Re Submission to exhibition of SSD-82709458 at 19-25 Balfour Street, Lindfield

We write on behalf of the owners of Nos 8 to 14 Highfield Road, Lindfield (“**our clients’ property**”) in relation SSD-82709458 at 19-25 Balfour Street Lindfield (“the development site”). Our clients’ property adjoins the site to the north and shares a common rear boundary with the development site. The relationship between our clients’ property and the development site is shown in the following diagram.

Drawn:
**OVERSHADOWING DIAGRAMS
(PROPOSED)**

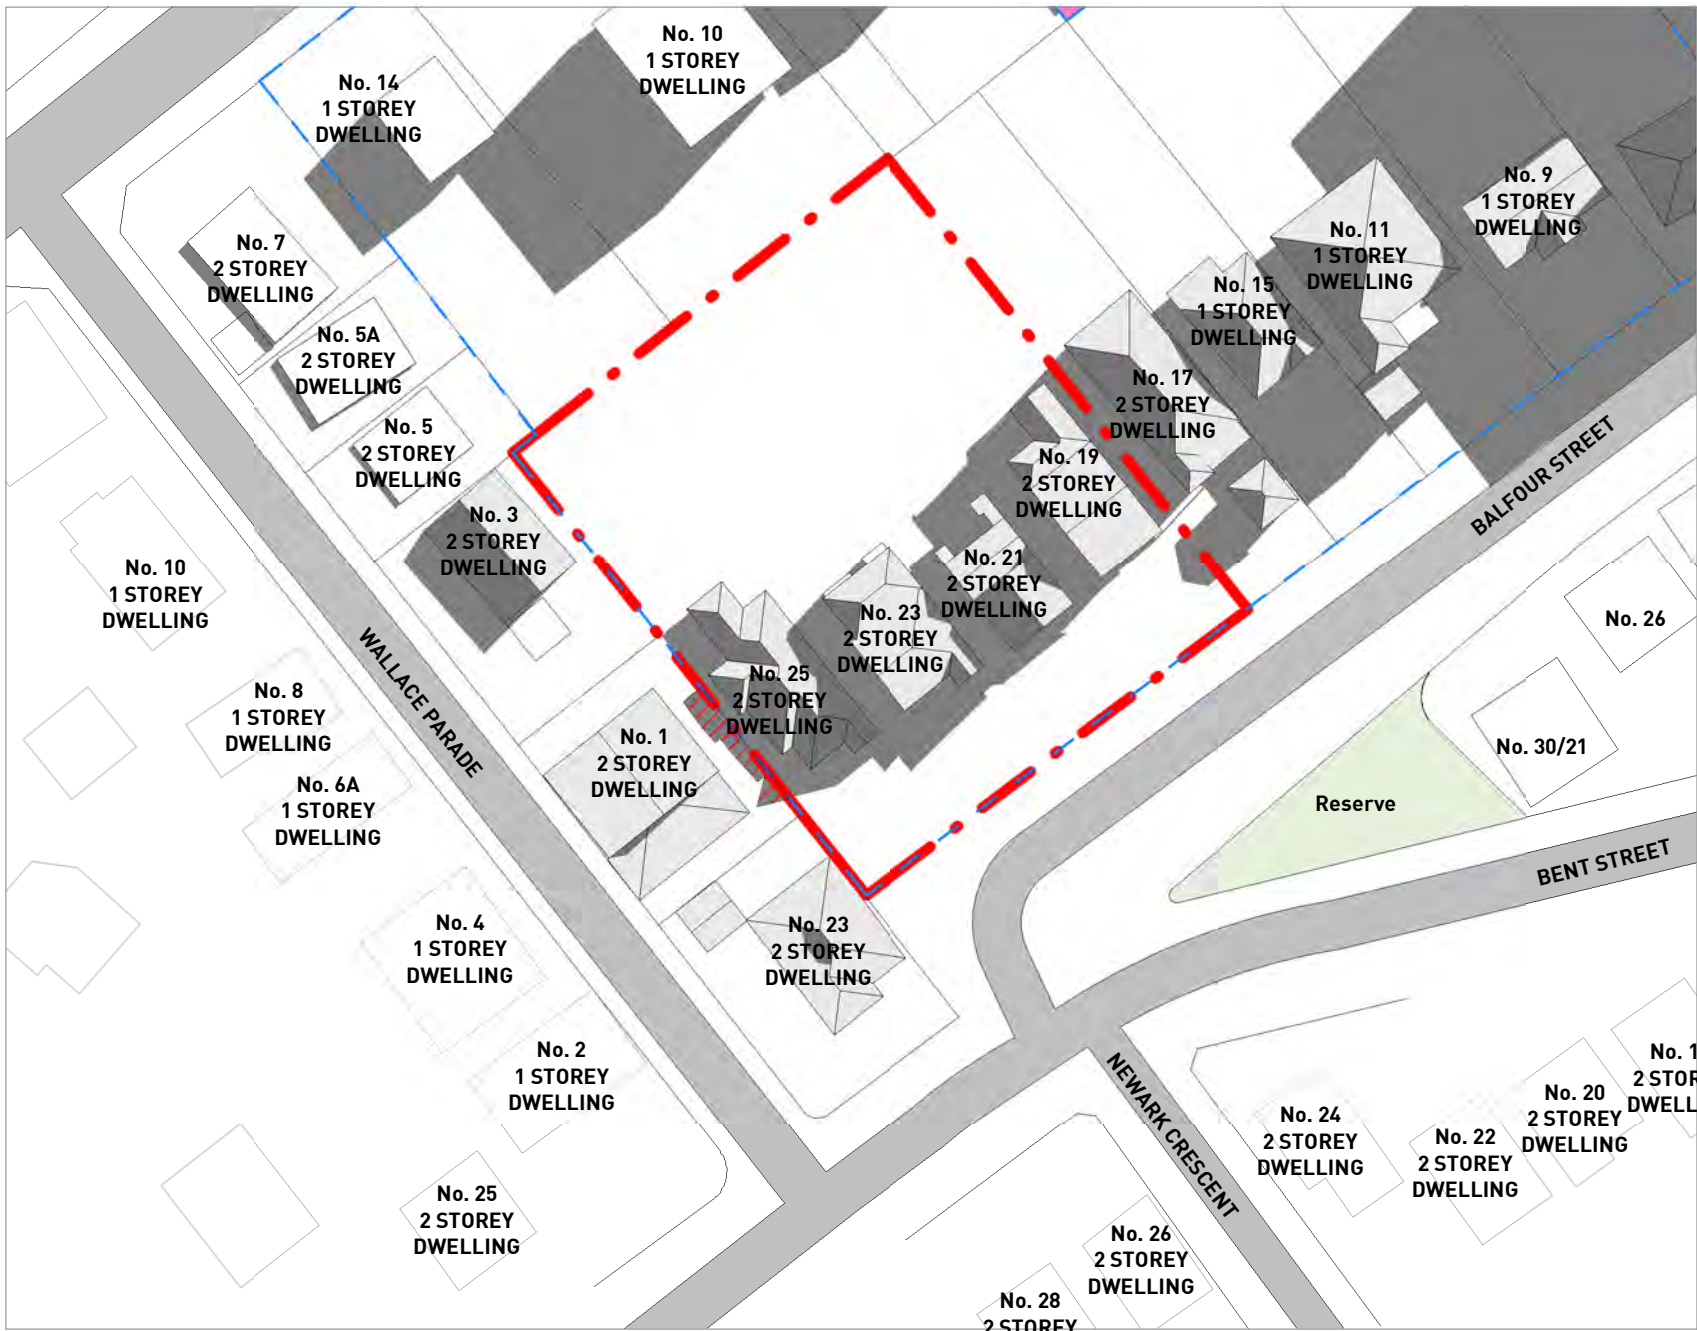
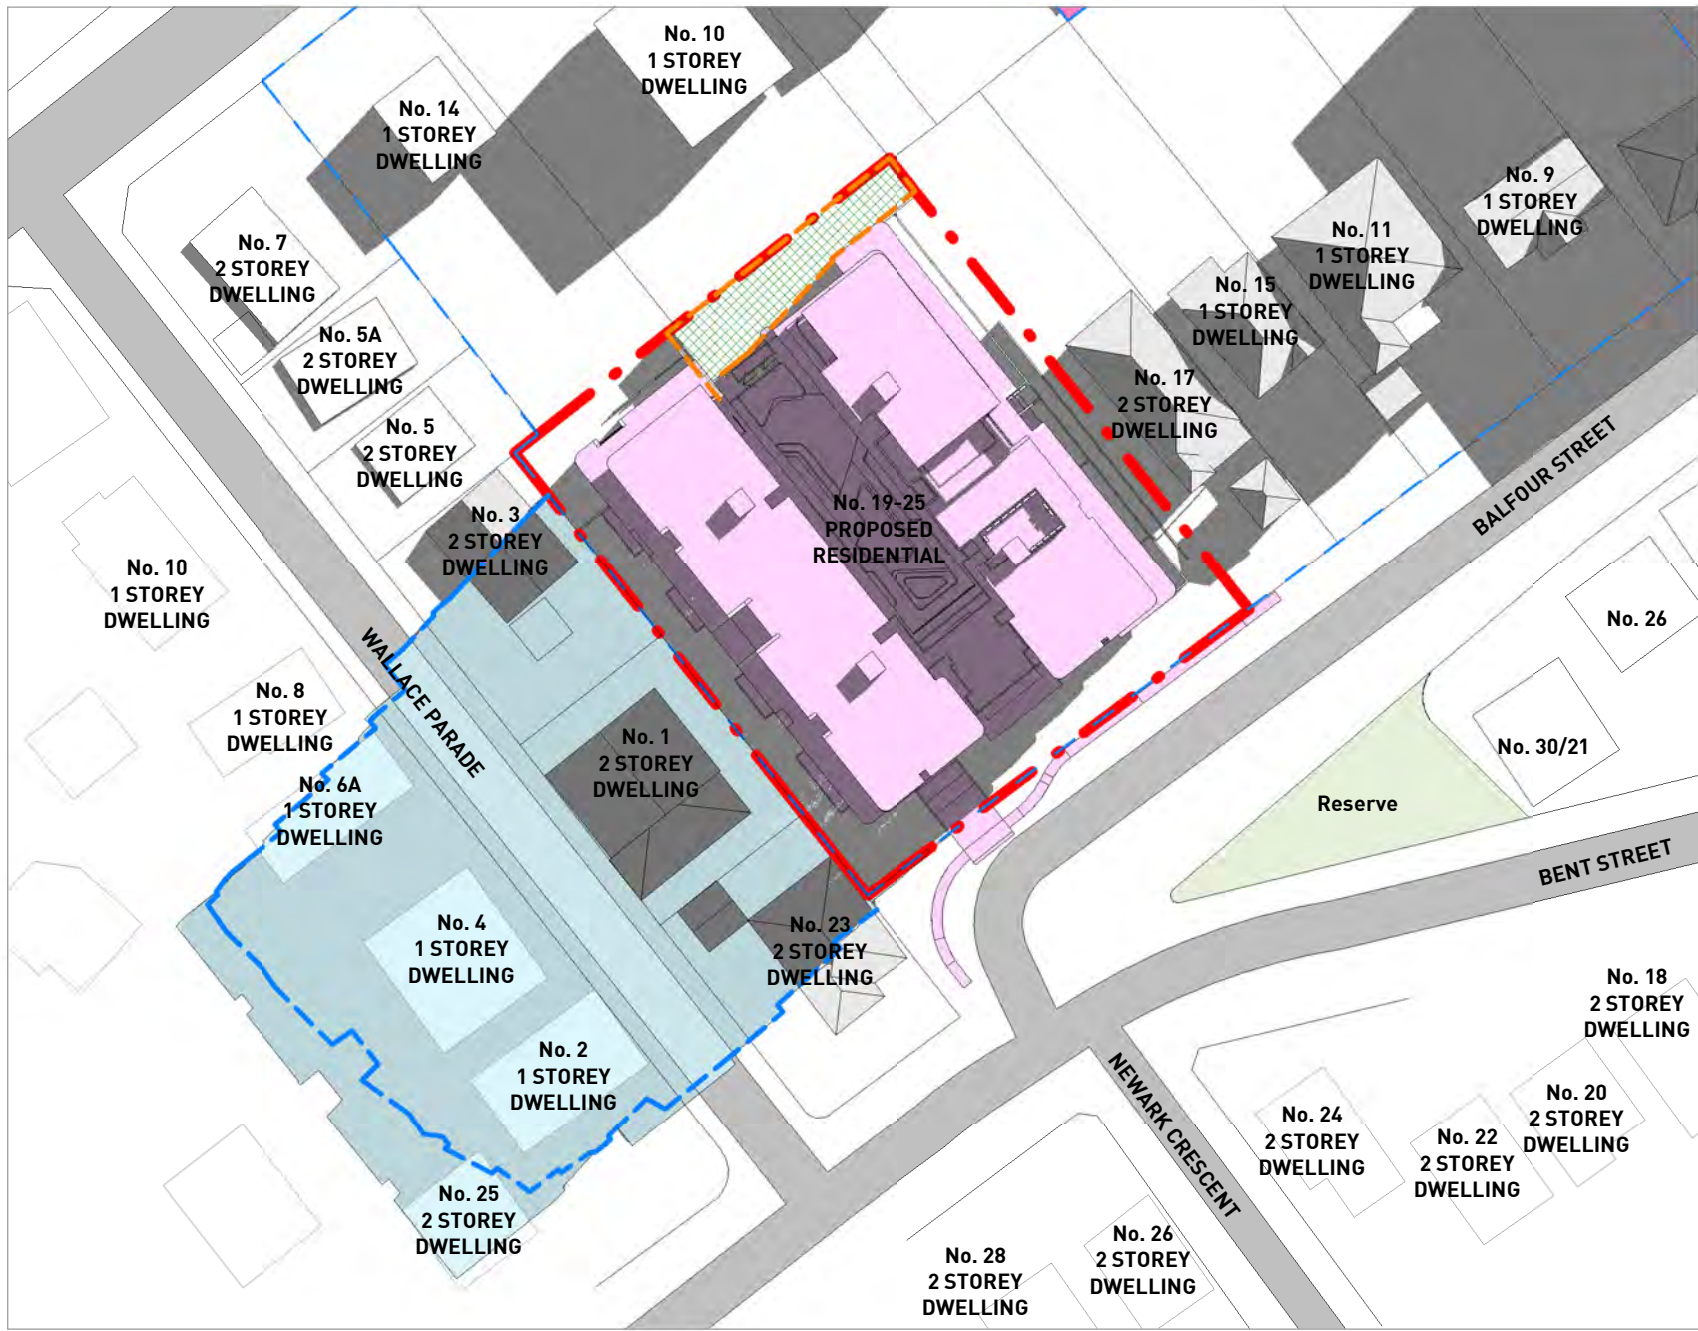
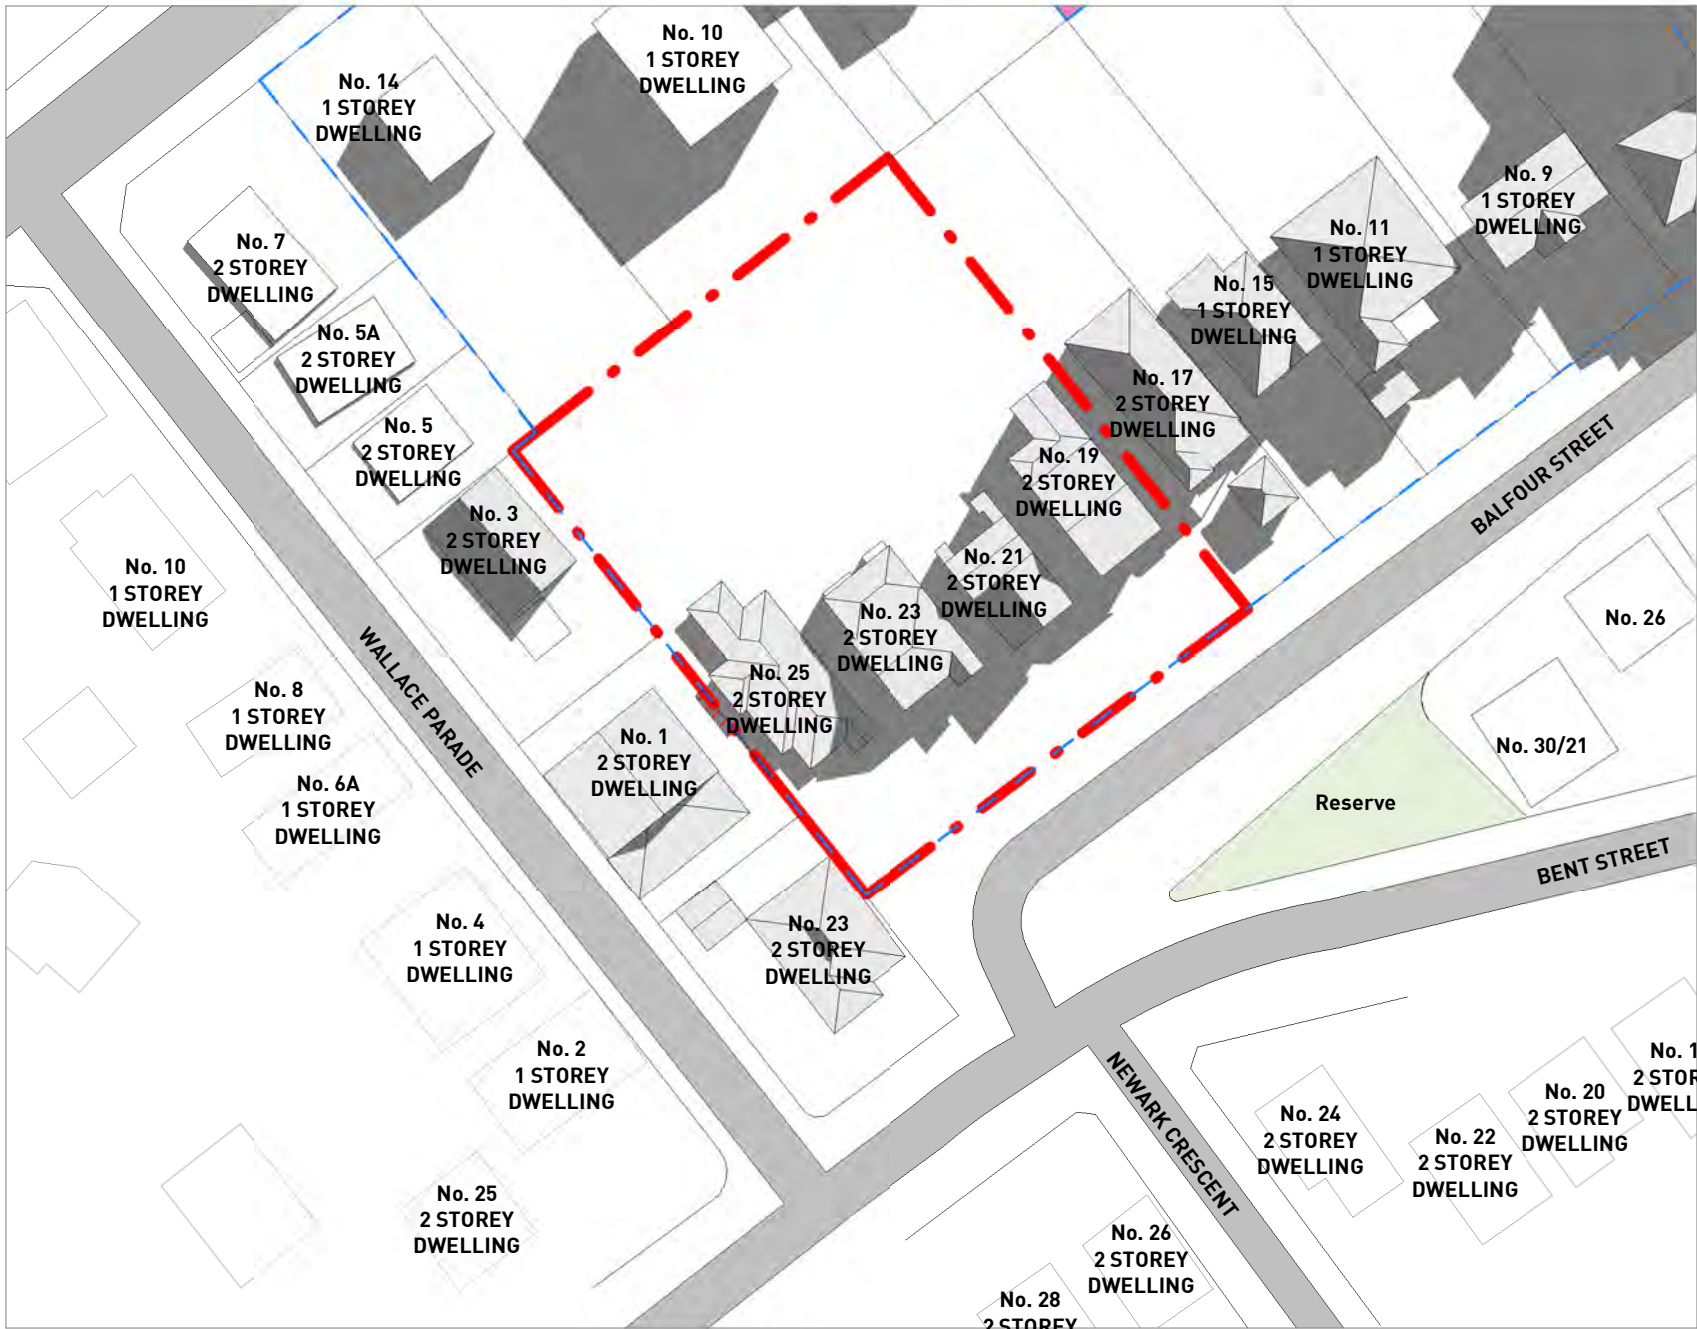
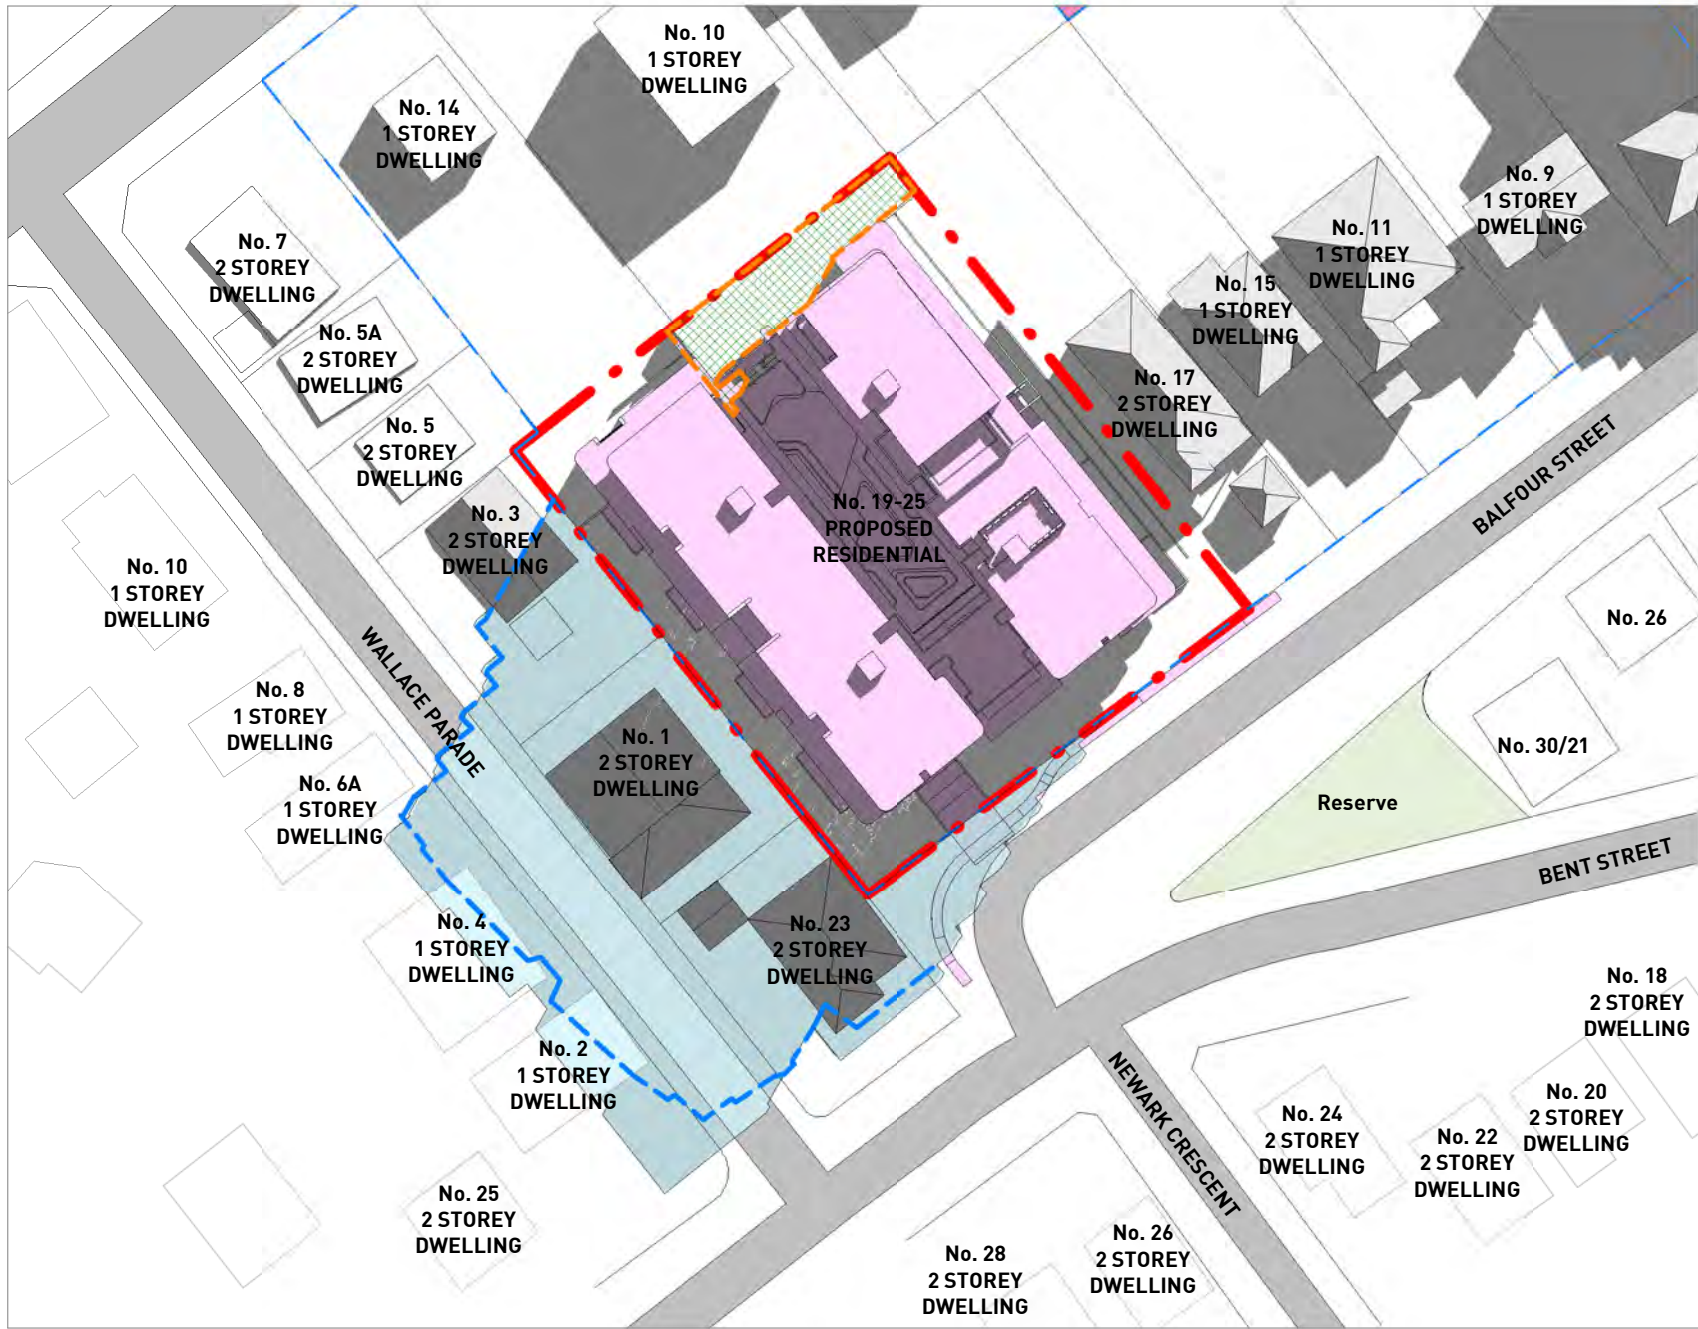
The shadow diagrams show that the proposed development will result in the loss of solar access at mid-winter to the rear yards of the adjoining three residential properties to the south

west from before 9.00am to 1.00pm. Councils preferred TOD alternative scheme indicated that these three properties have an FSR of 1.8:1. The narrow depth of these properties and the level of overshadowing will result in a significant reduction in amenity for these dwellings with the shadow not avoiding these properties until 2.00pm. This overshadowing is made worse by the non-compliant building height and the non-compliant building setbacks.
